The Planning Inspectorate
National Infrastructure Planning
Temple Quay House
2 The Square
Bristol
BS1 6PN
United Kingdom

JNCC Reference: OIA-10611
PINS Reference: EN010121
Date: 22 January 2025

Morecambe Offshore Windfarm Generation Assets – EN010121 – Marine Mammal response to the Examining Authority’s written questions and requests for information (ExQ1)

Plate 3.1 Flowchart diagram showing the mitigation process prior to piling (based on current Project design)

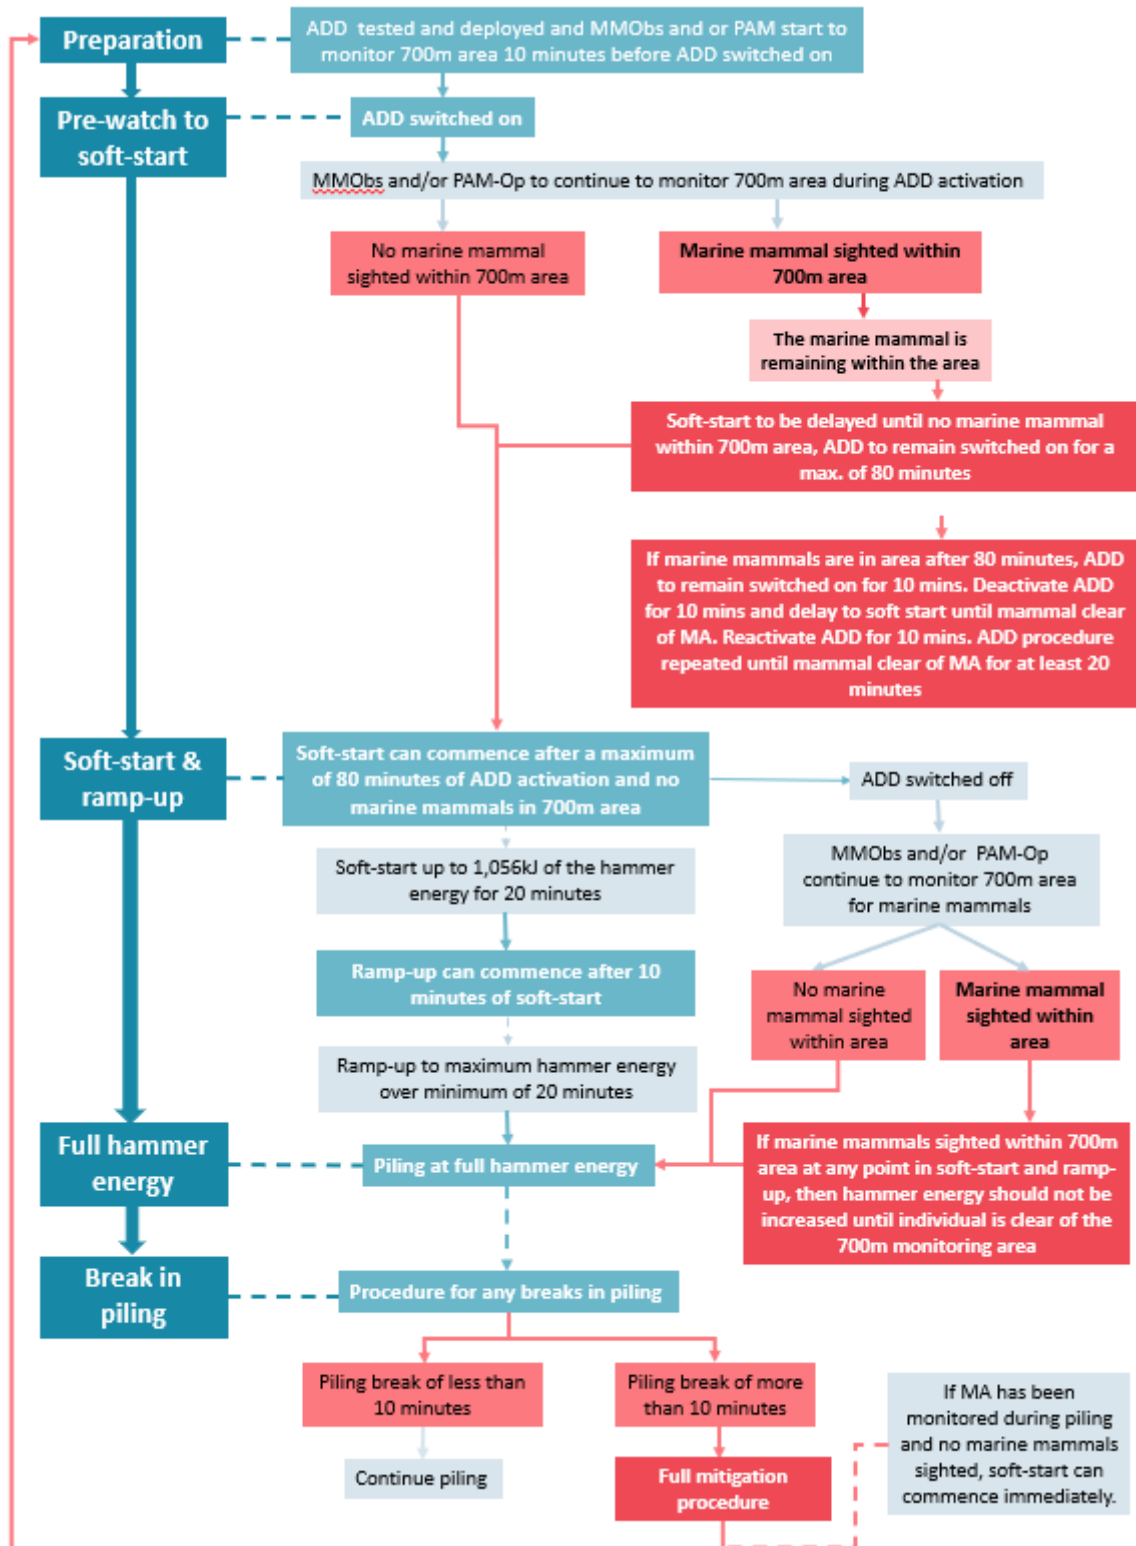
There are also inconsistencies regarding what the mitigation zone will be for visual surveys, i.e. it has been reduced from 700m to 500m in Paragraph 97 but Plate 3.1 and Paragraph 102 refer to a 700m zone. This needs clarifying. We highlight that the [SNCB mitigation guidelines](#) for piling should be considered a minimum requirement, and the size of mitigation zone adjusted to reflect, as best as possible, the predicted injury ranges. We also highlight that an update to these guidelines is planned for 2025.
